**From:** Thomas Callaway  
**Sent:** 16 September 2015 16:03  
**To:** Planning.Responses  
**Subject:** RE: Planning Consultation on: AL/78/15/HH

*Engineers comments in respect to surface water drainage:*

**APPLICATION AL/78/15/HH**

**Description of Works:** Single storey side extension

DRAWING TITLE: GROUND FLOOR PLAN AS PROPOSED	DRG NO: 06
DATE: 01/04/2015	REV: 00
SCALE: 1:100 @ A3	DRAWN BY: SJA

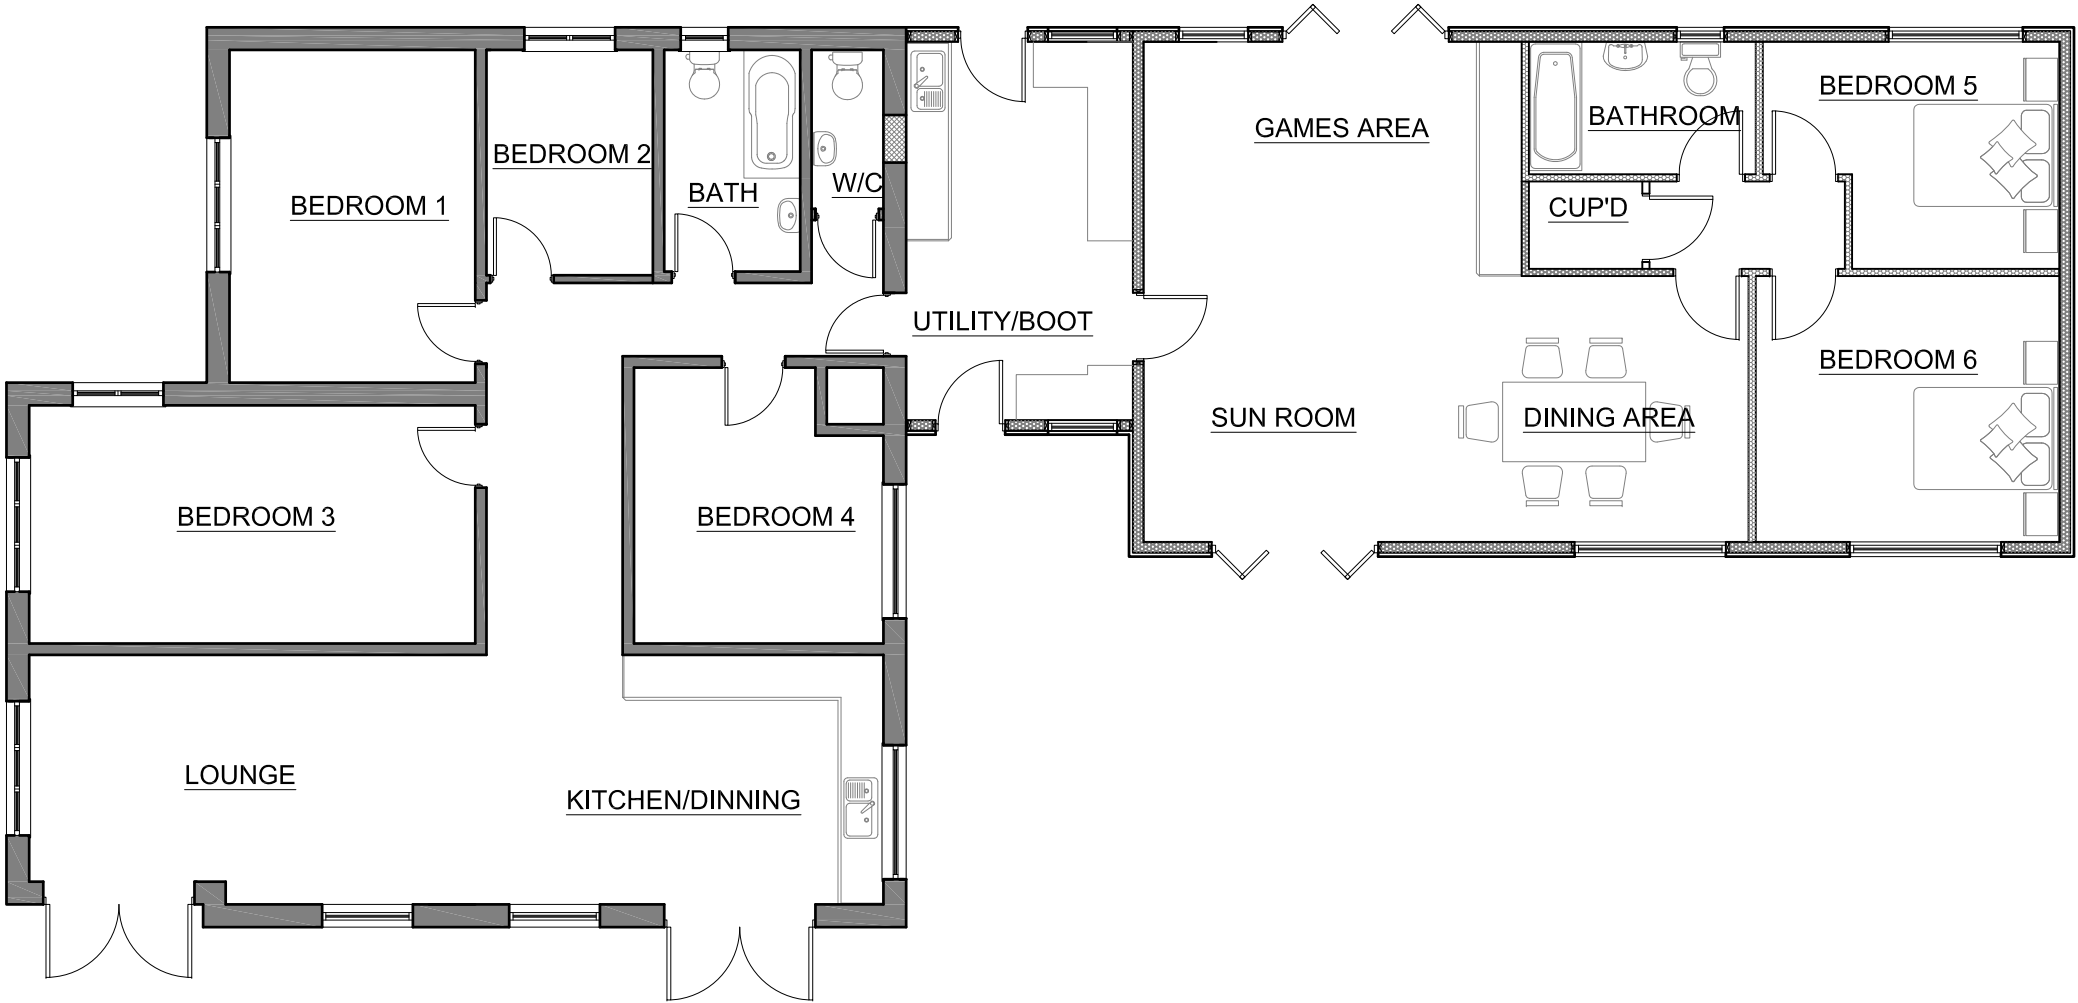
Infiltration must be investigated for new roof area.

Infiltration rates for soakage structures are to be based on percolation tests undertaken in the winter period and at the location and depth of the proposed structures. The percolation tests must be carried out in accordance with BRE 365, CIRIA R156 or a similar approved method and cater for the 1 in 10 year storm between the invert of the entry pipe to the soakaway, and the base of the structure. It must also have provision to ensure that there is capacity in the system to contain below ground level the 1 in 100 year event plus 30% on stored volumes, as an allowance for climate change. Adequate freeboard must be provided between the base of the soakaway structure and the highest recorded annual groundwater level identified in that location.

Any SuDS or soakaway design must include adequate groundwater monitoring data to determine the highest winter groundwater table in support of the design. The applicant is advised to discuss the extent of groundwater monitoring with the Council's Engineers. Supplementary guidance notes are also enclosed for information
